Please ask for: Nicola Moore
Email: nicola.moore@arun.gov.uk
Telephone: Ext 37944
Our Ref: BR/274/20/CLP
Your Ref:
Date: 17th November 2020

Lawful Development Certificate for a Proposed Use or Development

Development: Lawful development certificate for Proposed increase in area of garden from neighbouring property at 184 Hawthorn Road.
Location: 188 Hawthorn Road Bognor Regis PO21 2UX

LOCATION PLAN 1:1250

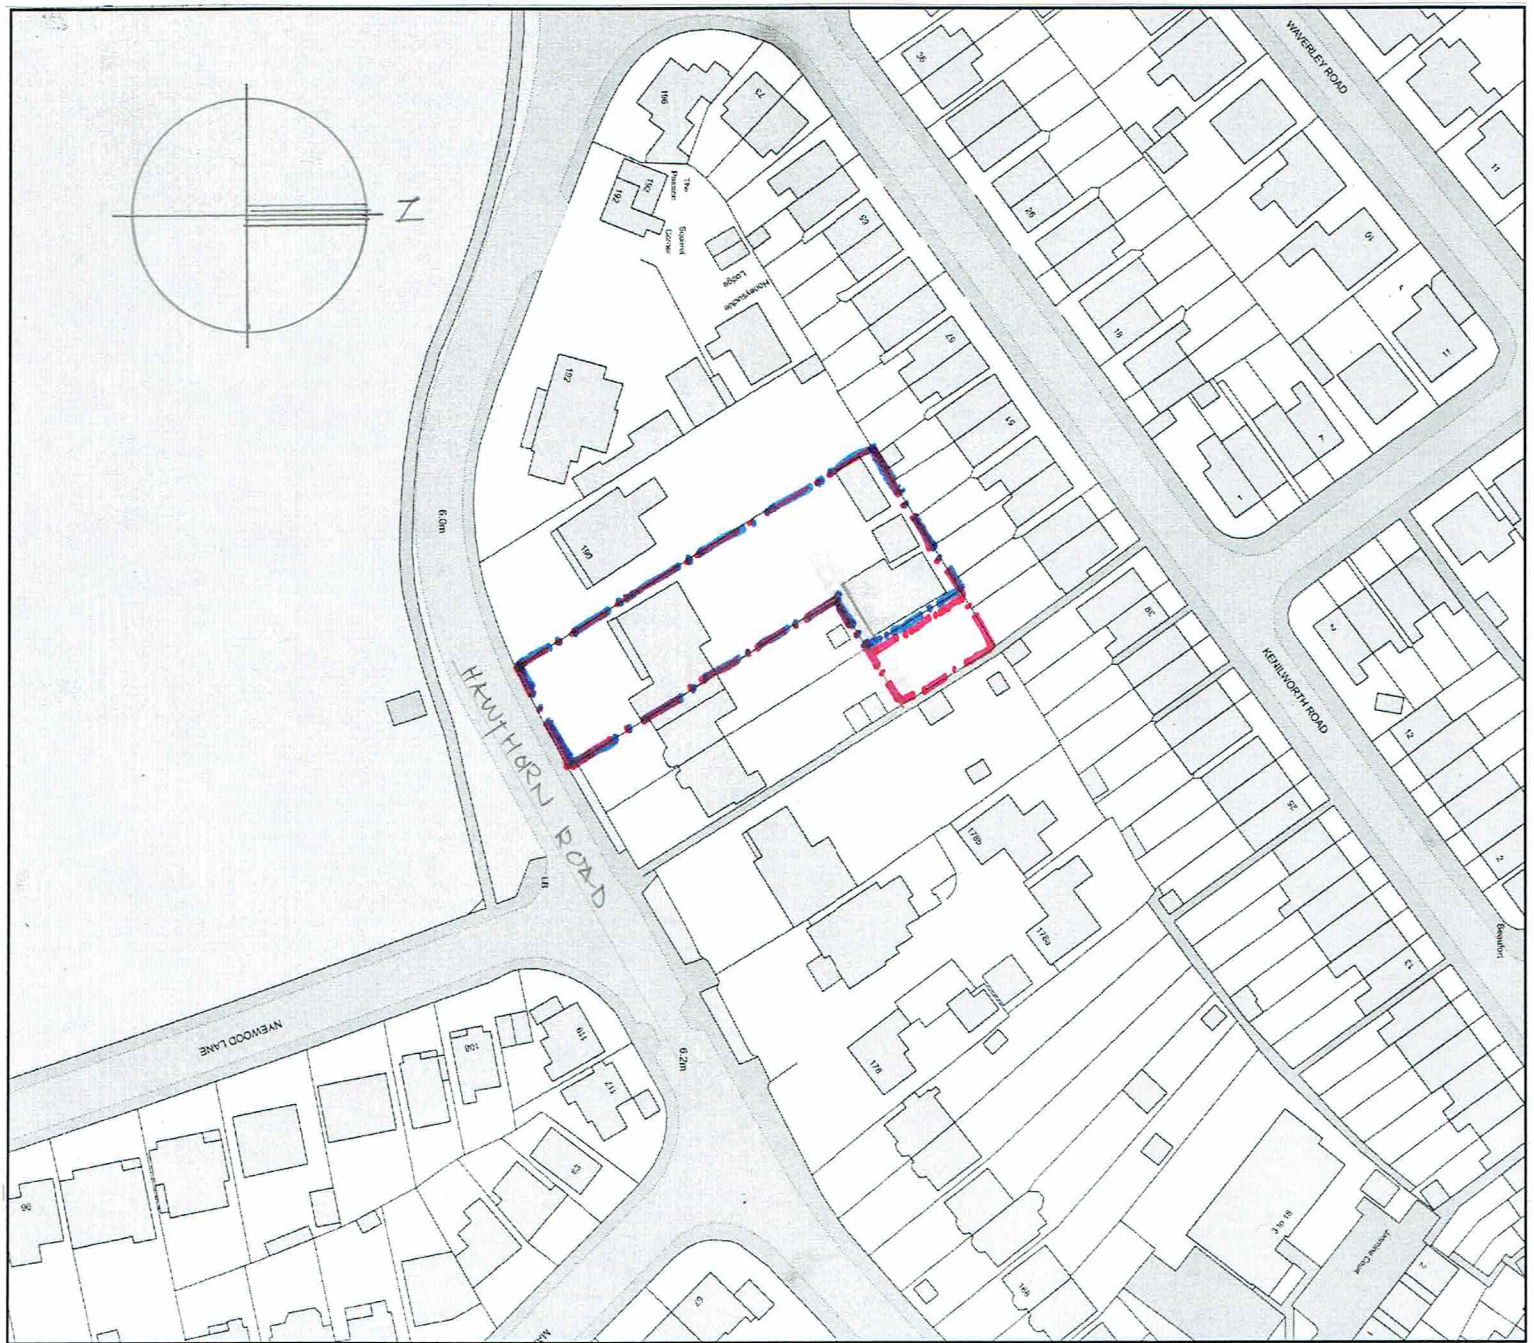
Location Plan

The area of garden to be added to the existing garden should be edged in red, and the existing site and garden should be edged in blue. Please amend accordingly and resubmit

BLOCK PLAN 1:500

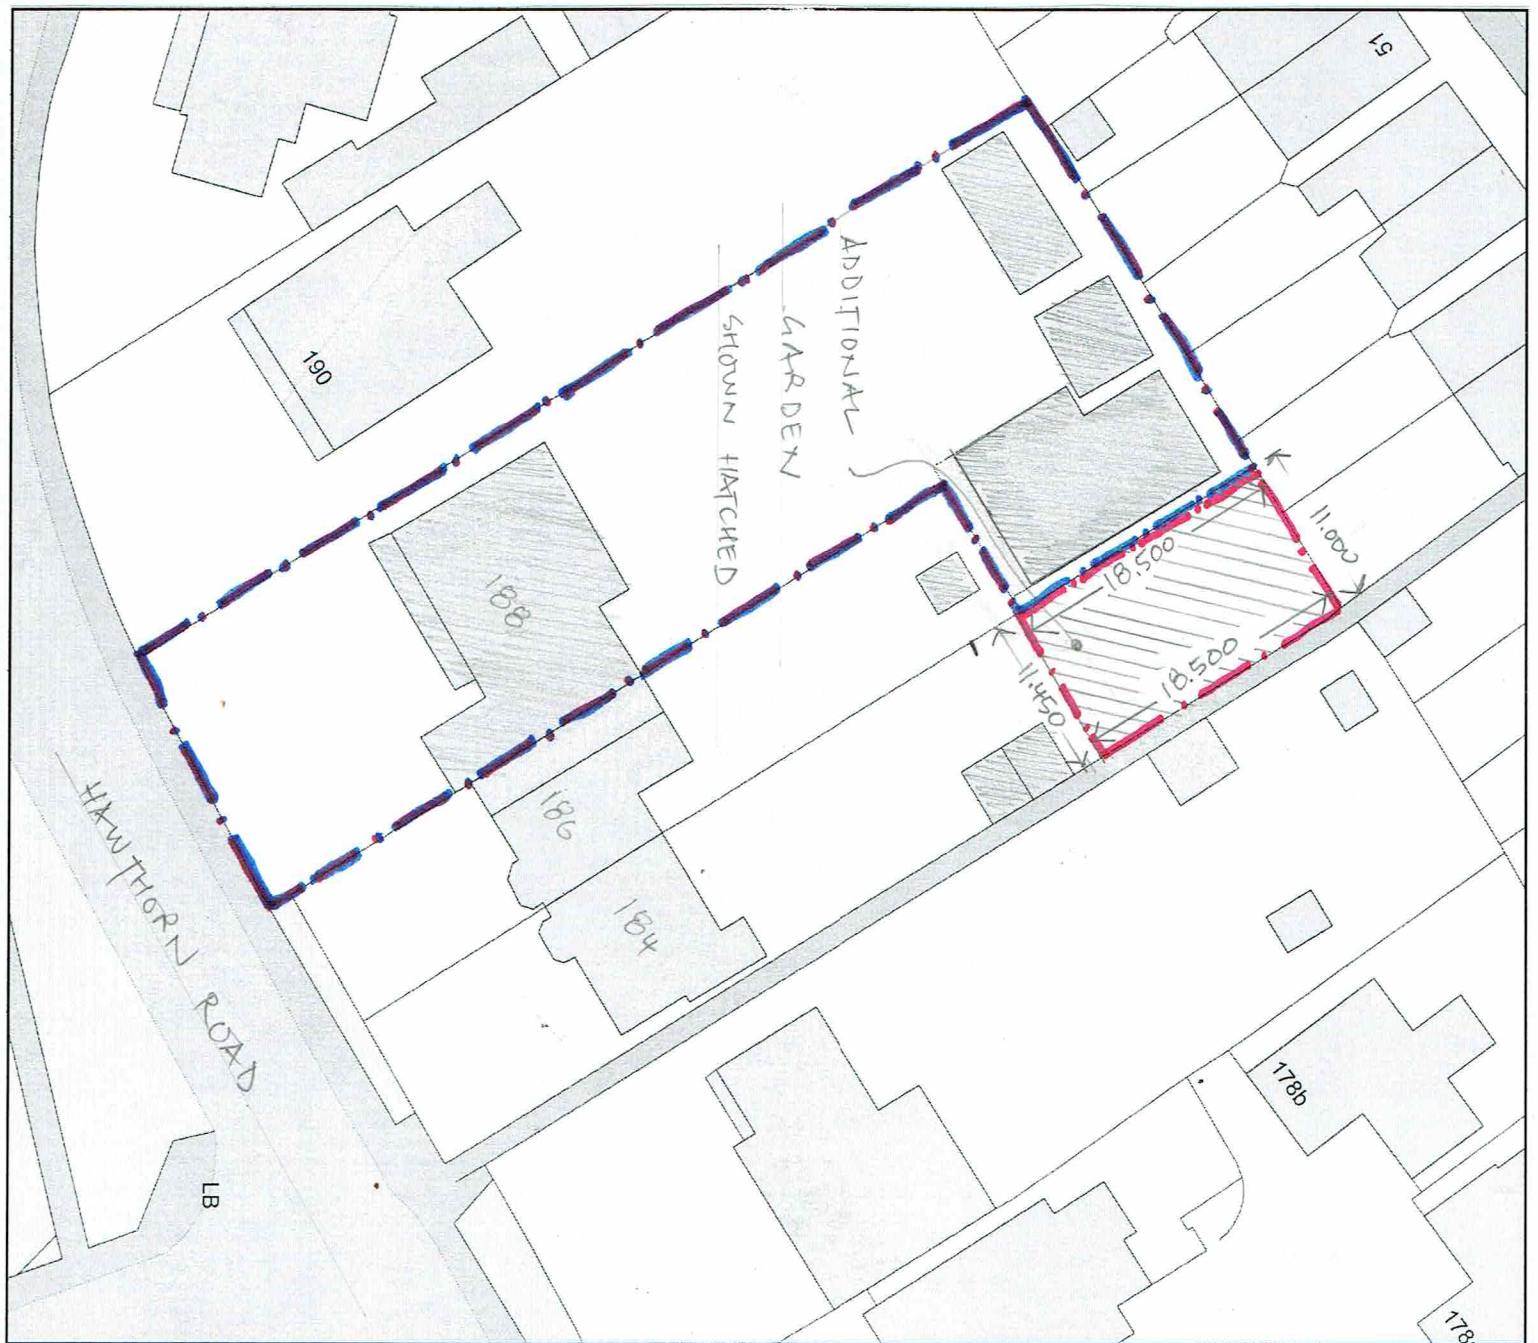
Block Plan

The area of garden to be added to the existing should be edged in red, and the existing site/garden should be edged in blue. Please amend accordingly and resubmit.
